Crime Impact Statement

Outline Planning Application 3/2016/0146 with all matters reserved for residential development of 23 dwellings with access, parking, and associated landscaping following demolition of No.s 23, 25 Old Row, Whalley Road, Barrow

drawing: **PROPOSED SITE LAYOUT**

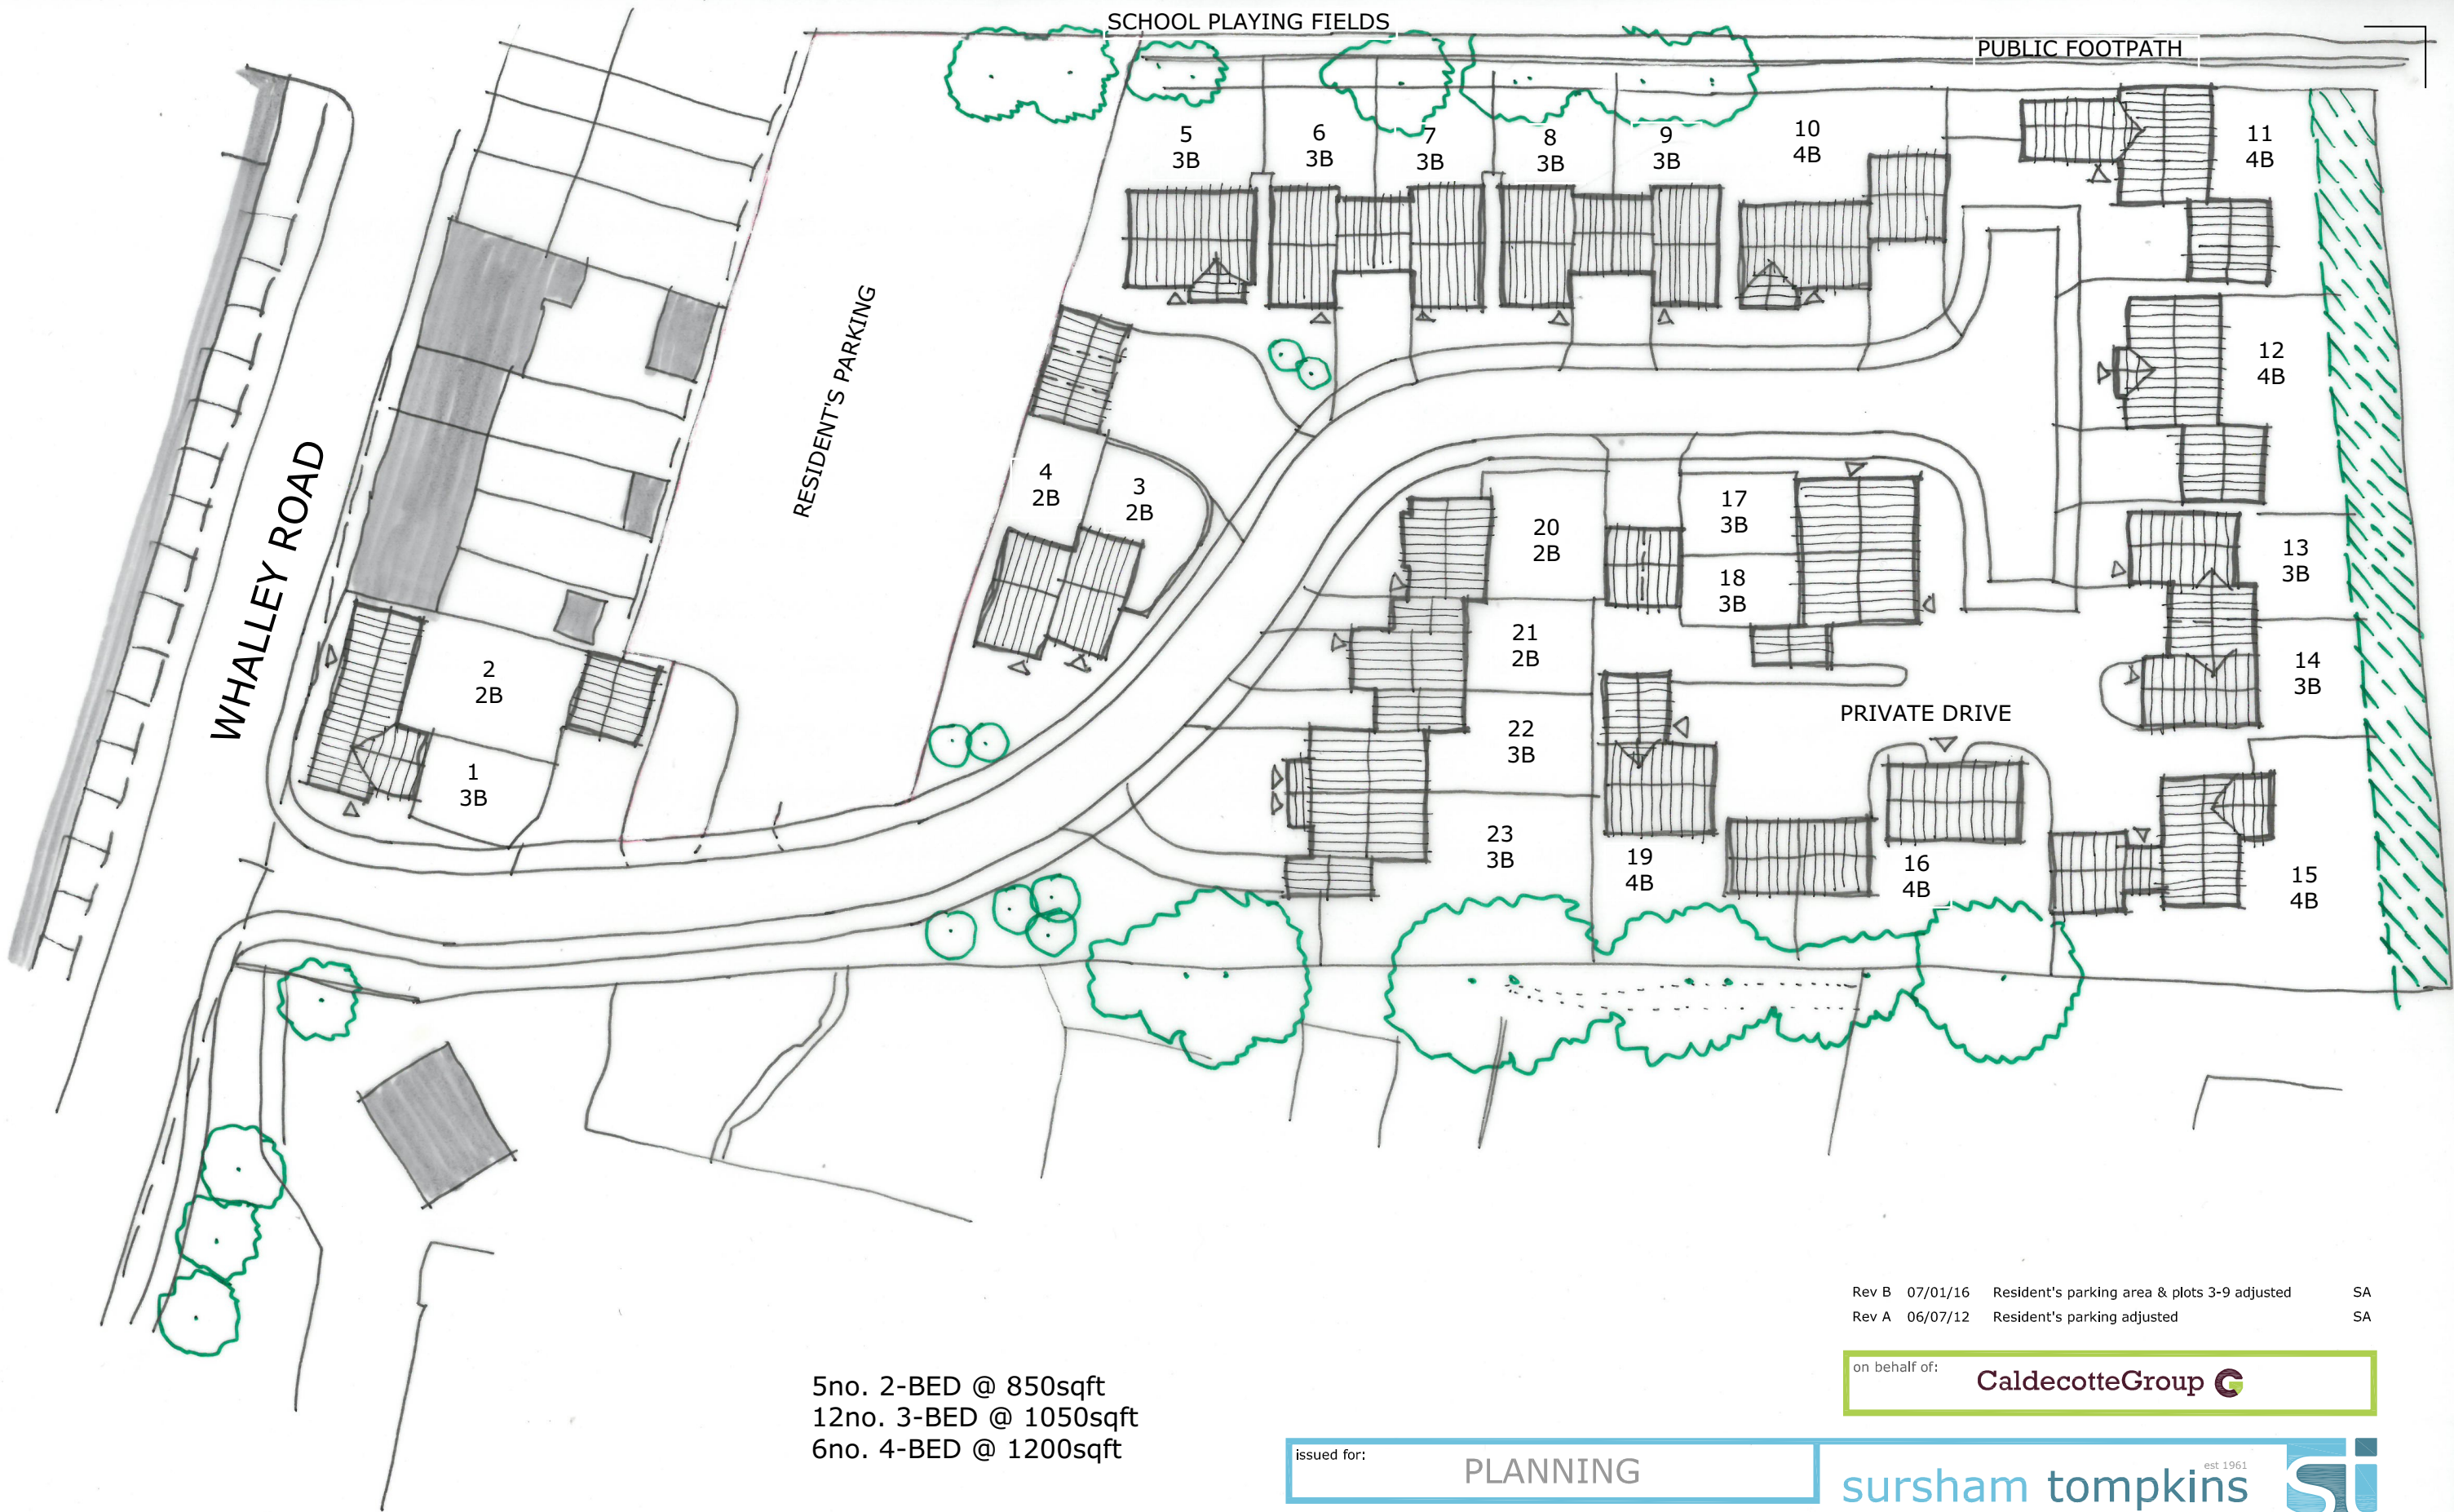
- The indicative layout suggest that differing orientation of the dwellings allows good natural surveillance around the development, this together with a cul de sac arrangement would deter a casual intruder looking for opportunist crime as they would be more likely to stand out and be observed or challenged. Good natural surveillance helps to reduce crime and anti-social behaviour.

- Link footpaths in cul de sacs should be avoided as they compromise the security initially gained by the layout by providing an access and escape route and also a *legitimate reason* for being there – ‘I was just passing through’.
- Lighting at external doors and good, even coverage of street lighting enables views within the development when natural light is minimal. Landscaping should be designed so that trees will not grow to obscure lighting columns.

- In curtilage parking reduces the opportunity for auto-crime. The layout suggests that parking is in curtilage. Any additional parking provided for residents or visitors should be well overlooked by nearby dwellings.
